## RE: Resubmission of SDD 8588 (Mod 3) - Eastern Creek Business Hub Stage 1

Ethos Urban has prepared this letter on behalf of Frasers Property Australia in response to your letter dated 22 August 2019 requesting additional information prior to acceptance of the modification application. **Table 1** below outlines our response to each of the matters raised.

drawing title
PROPOSED ROOF PLAN -
STAGE 1

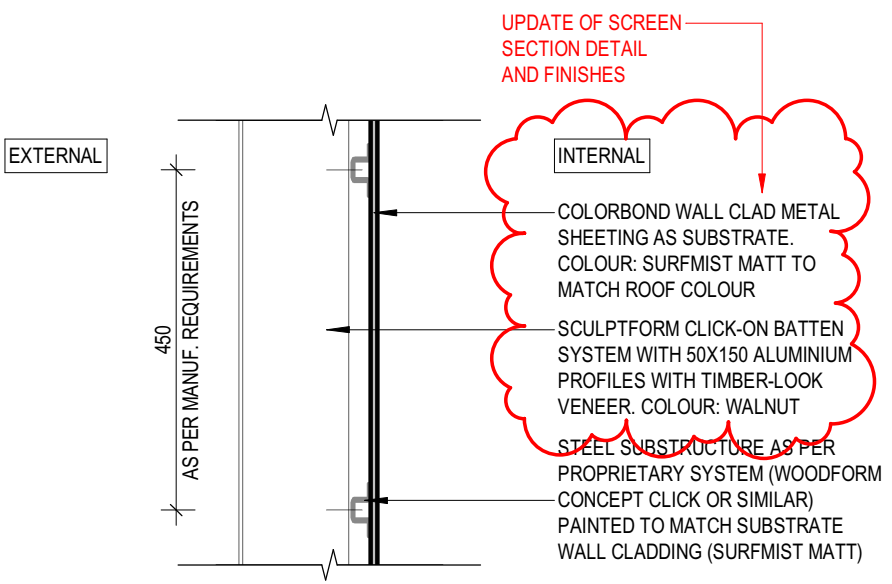
<b>4. Screening Detail</b> Provide elevation detail, in addition to the section detail, of the new screen cladding around the plant room and condenser deck as identified on the roof plan. Also confirm the colour of the timber look veneer proposed for the cladding.	No change is provided to the screening detail around the plant room, except for a minor change to materials. SSD 8588 MOD 1 approved the current screening and it is now only proposed to introduce a timber-look veneer to reflect the character of the centre. Therefore, the detailed sections remain as approved and an updated material sample has been submitted.
<b>5. Site Plan Changes</b> Provide additional detail/ clarify the following changes: <ul style="list-style-type: none"> <li>The new concrete egress path marked at the top of the site plan is shown on the approved site plan</li> </ul>	This item has been removed from this application.

FLOOR PLAN - PARKING AREA SHADE SAILS 1 : 200

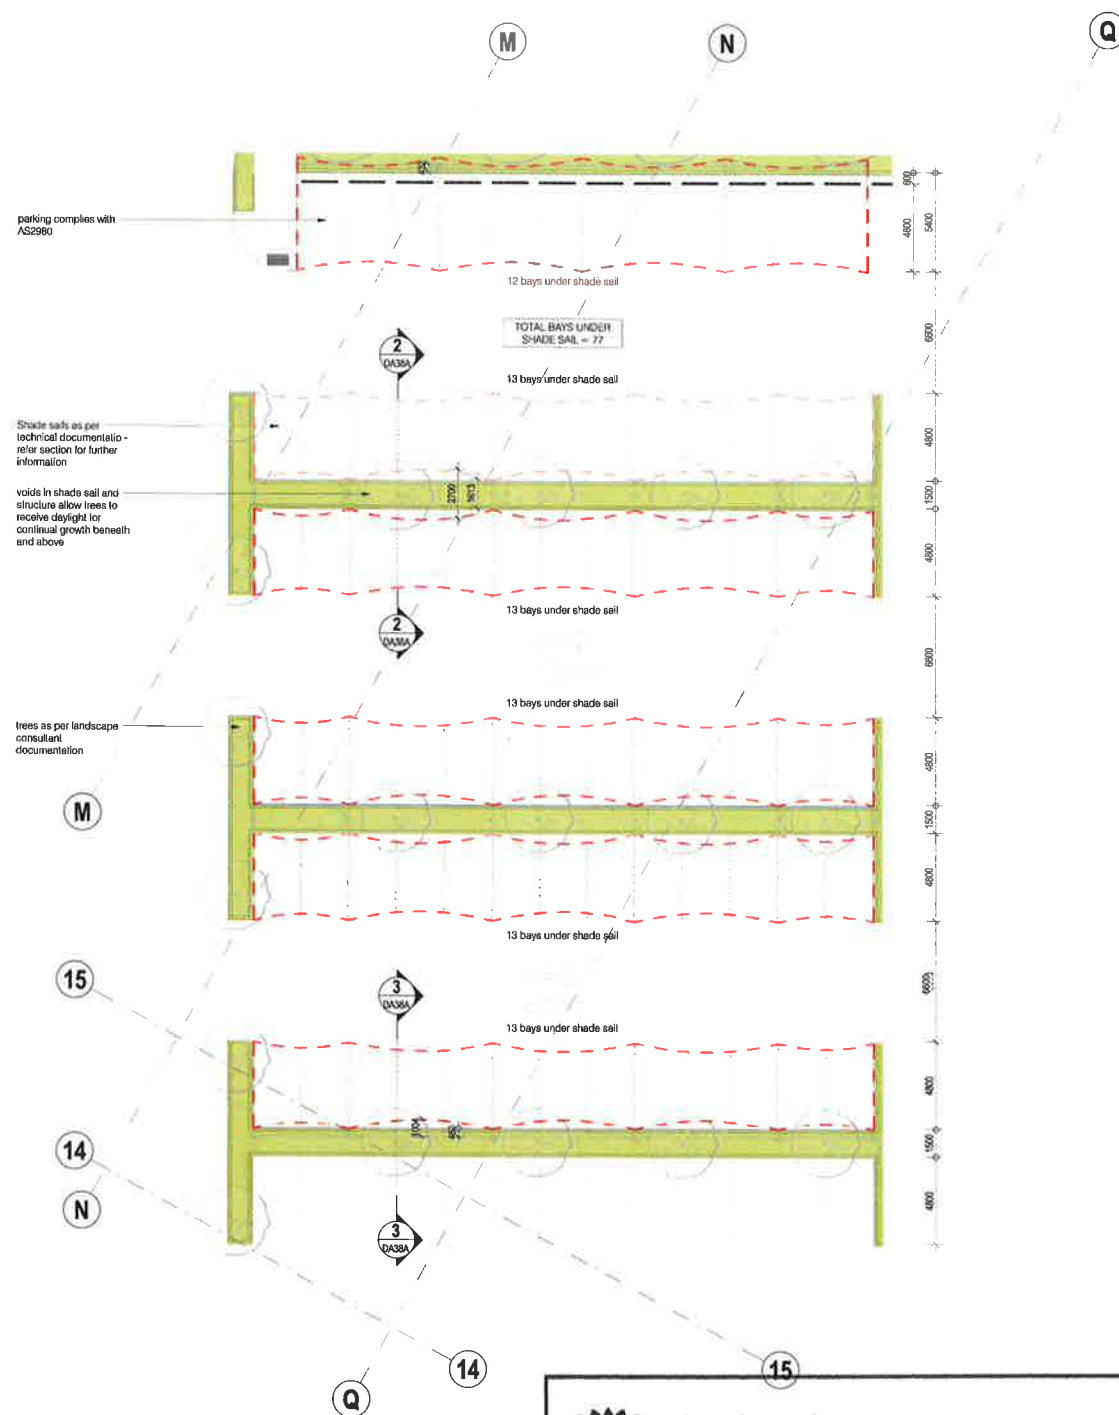
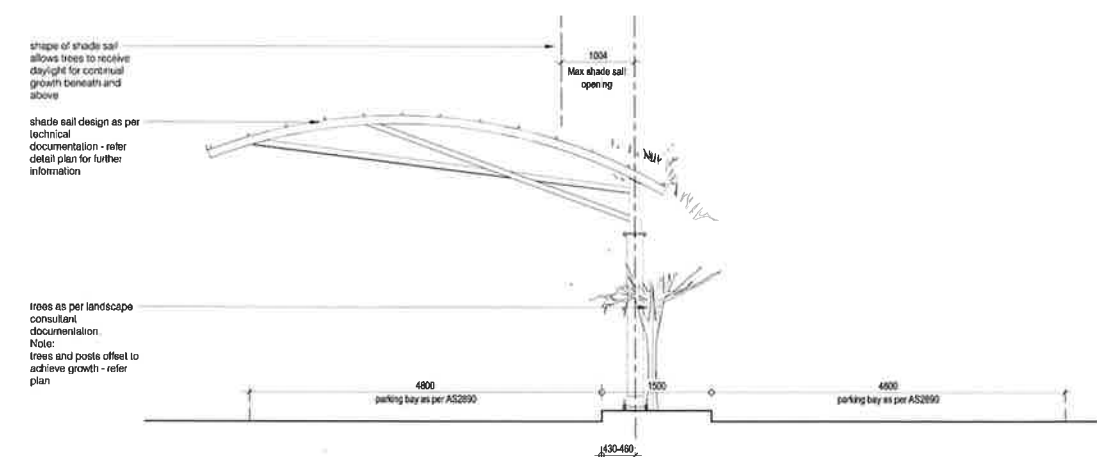
<p><b>2. Shade Sails</b> Additional detail is required demonstrating how the landscaping and tree planting in the carpark will be impacted by the proposed shade sails. This detail is to be provided on an updated plan including a landscape plan.</p>	<p>Additional plans are included as part of the amended application demonstrating the relationship between the shade sails and trees.</p>
<p>Provide additional information for the reason and location of the proposed shade sails.</p>	<p>The shade sails are required to provide additional sun protection to the car park and have been requested to support the leasing of major tenancies in the centre. The location of the shade sails has been selected as these car spaces are located furthest away from the main retail centre and are therefore the least amenable. The shade sails will improve the amenity of these spaces and make them more attractive for customers. In addition, the proposed shade sails are located to the rear of the site and therefore will not detract from the character or appearance of the centre when viewed from Rooty Hill Road South.</p>

<p>Identify how many car spaces the shade sails will cover.</p>	<p>The shade sails will cover 77 car spaces. This is now shown on the architectural plans submitted with the amended application.</p>
